Inspector's Written Questions for Birtley to Coal House DCO

Ref	Question	Lead	Comment
1.0.1	<p>Chapter 5 of the Applicant's Planning Statement [APP-171] includes an assessment of the relevant local planning and transport policies.</p> <p>a) Which documents constitute the Development Plan for each local authority area?</p> <p>b) Do you agree with the list of relevant policies set out by the Applicant in this document? Are there any additional policies you consider to be relevant to the proposal? If so please provide them along with a justification for their relevance.</p> <p>c) Are there any relevant emerging policies? If so, what is their current stage in the plan adoption process?</p> <p>d) Please provide copies of all relevant adopted and emerging policies.</p>		<p>Andrew Haysey to coordinate Transport input.</p> <p>Please refer to Gateshead's LIR.</p> <p>Additional policies and links to documents contained within LIR.</p>

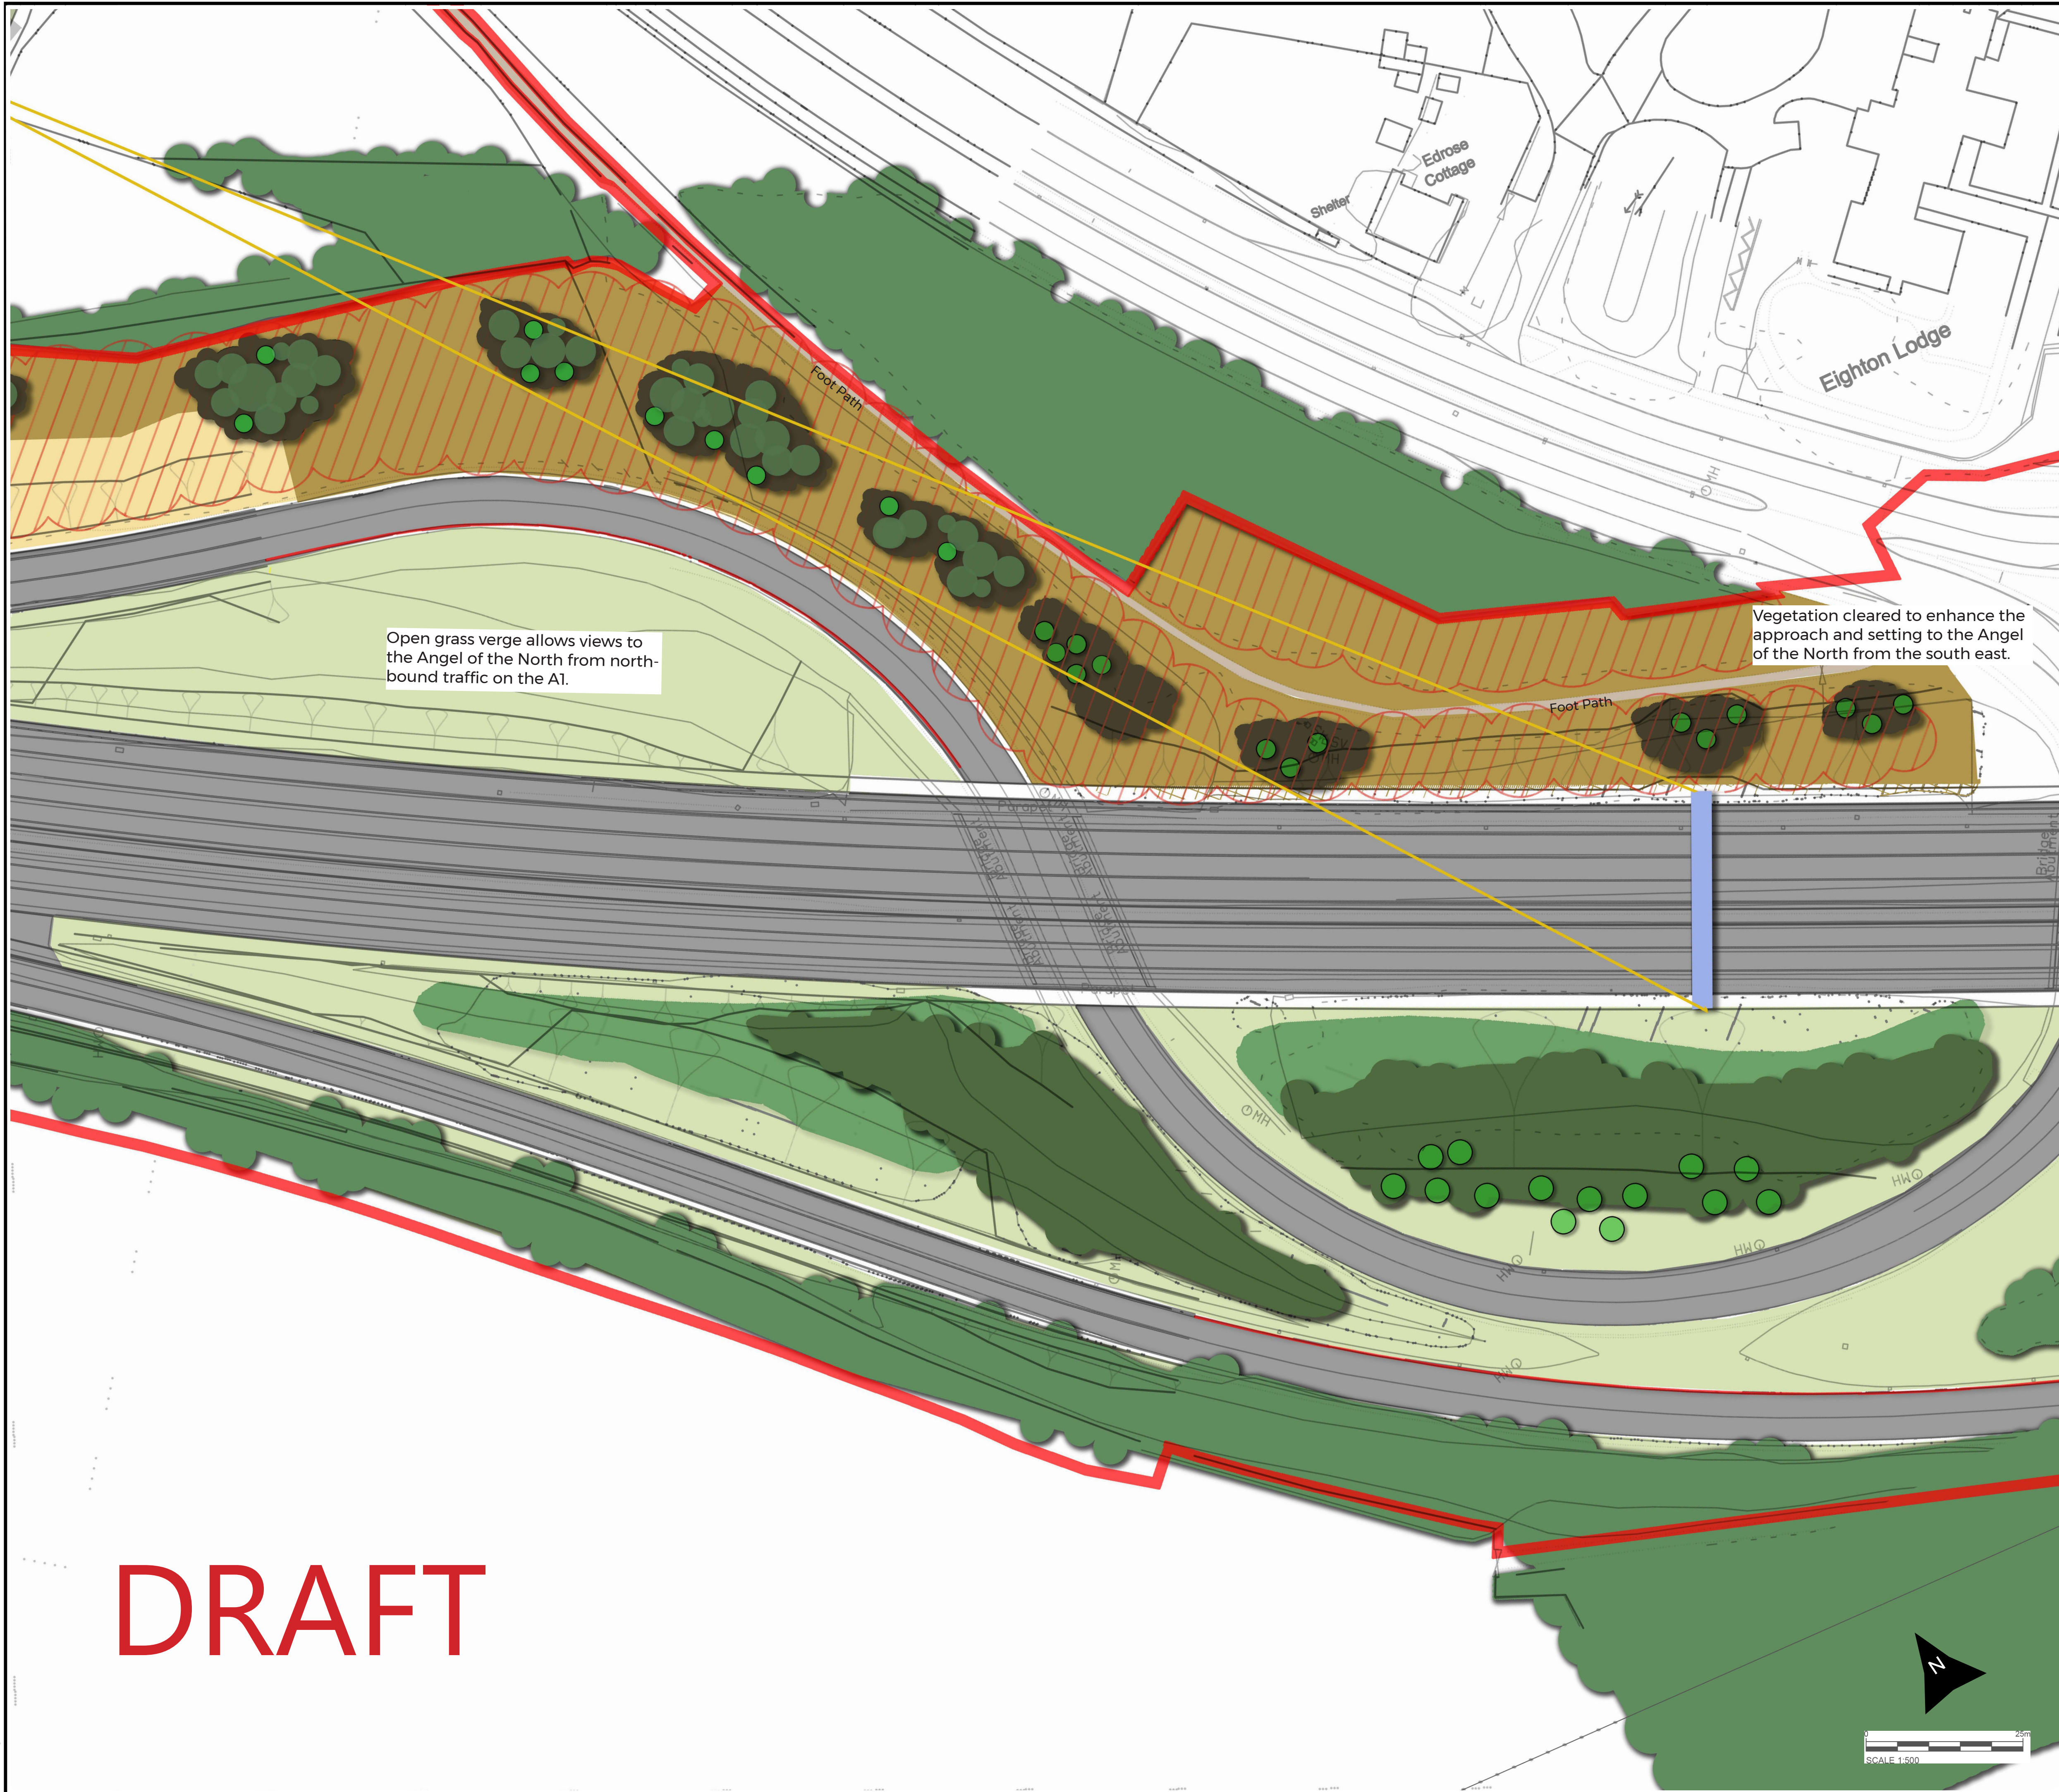
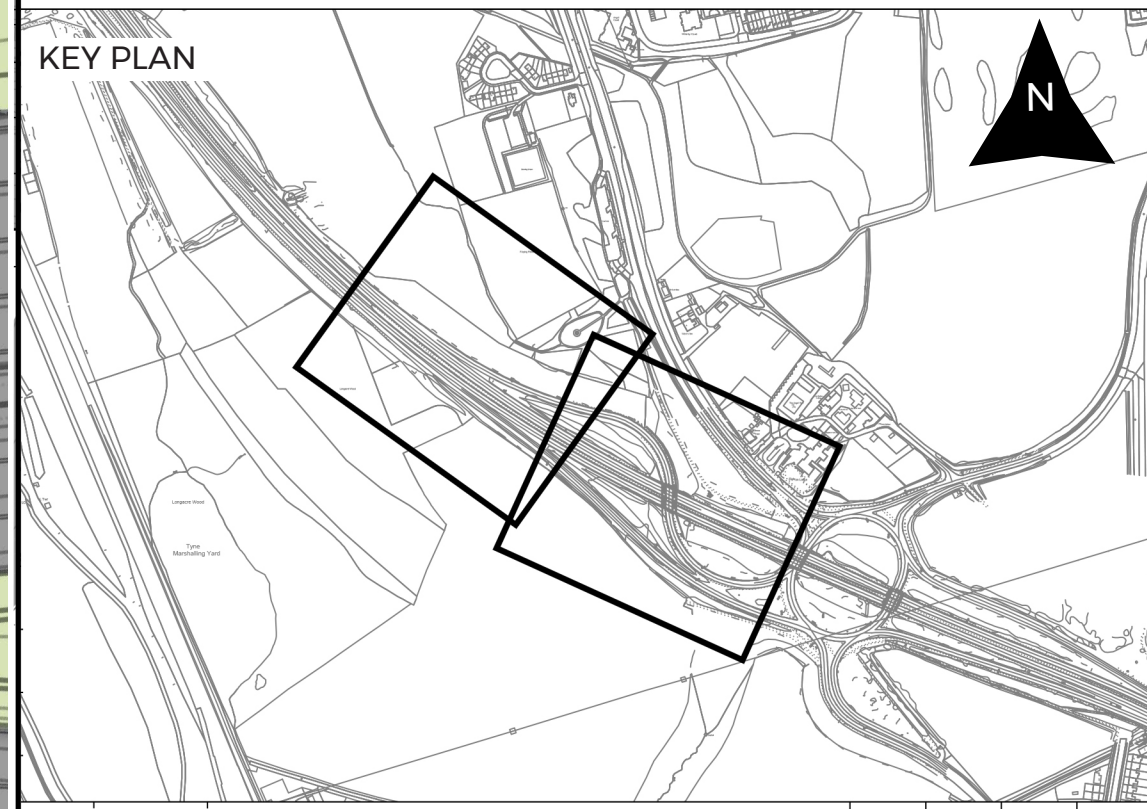
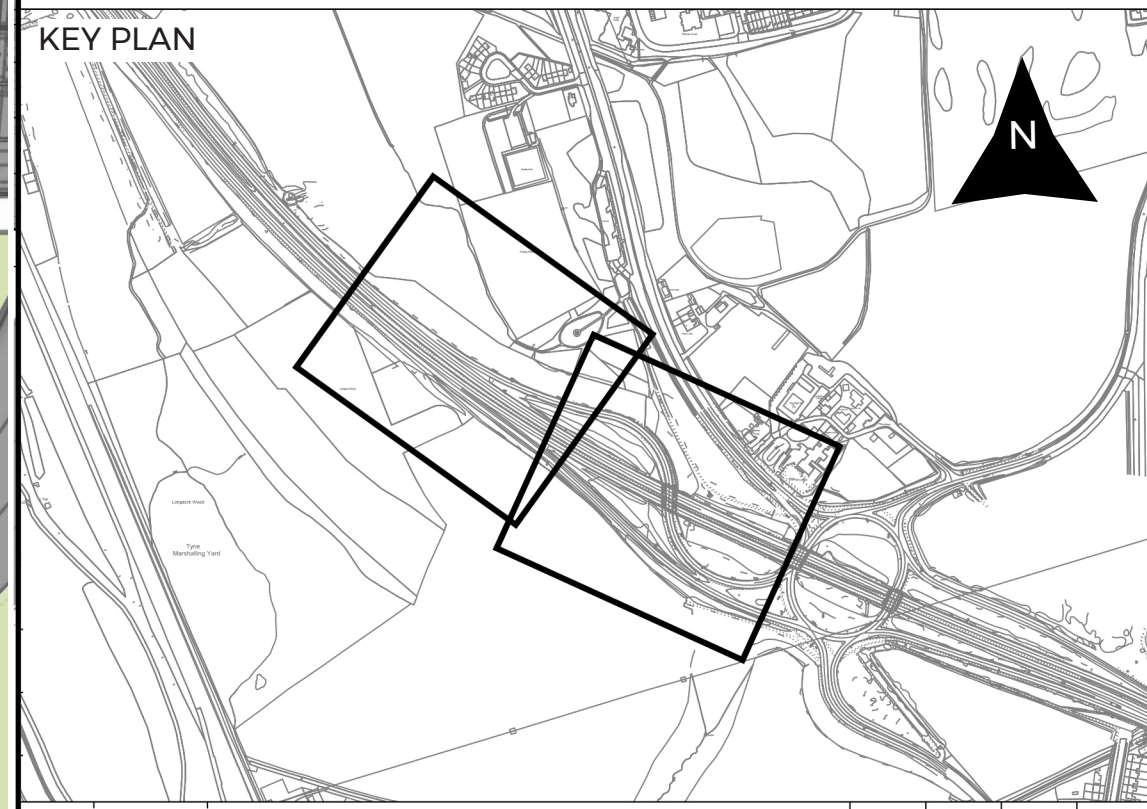
There is a clear concern that the position of the gantries will directly, and negatively affect views of the Angel as defined in the NECT 2018 study (submitted). The DCO does not currently specify the actual positions, nor provide enough visual information to identify the level of impact (despite this being requested). There is clear presumption against the obstruction of, or restriction of significant views of the Angel.

The DCO should seek to secure the above information prior to approval to allow discussion with the Council. Draft view analysis shows that the impact will be significantly harmful and more so on the north bound side than the south bound.

The immediate setting of the Angel will be changed considerably by the removal of all vegetation. See above regarding the agreement for a coherent landscape scheme and mitigation for tree planting and biodiversity.

The draft requirement 5 should specifically reference the design of a combined landscape across Council and Highways England land, in partnership with the Council, at the Angel. Draft CEMP part CH1 and L14 should be amended to reflect the agreed approach based on the SG report. Figure 7.6 in chapter 7 of the ES should be amended.

The draft DCO requirement 5 requires the landscaping scheme to be approved by the SOS following consultation with the LPA. The draft CEMP states that, at CH1 replanting at the Angel will be less dense to enable the Angel to be visible and at L14 that existing planting south of the Angel will be subject to woodland management to improve views/visibility of the Angel.
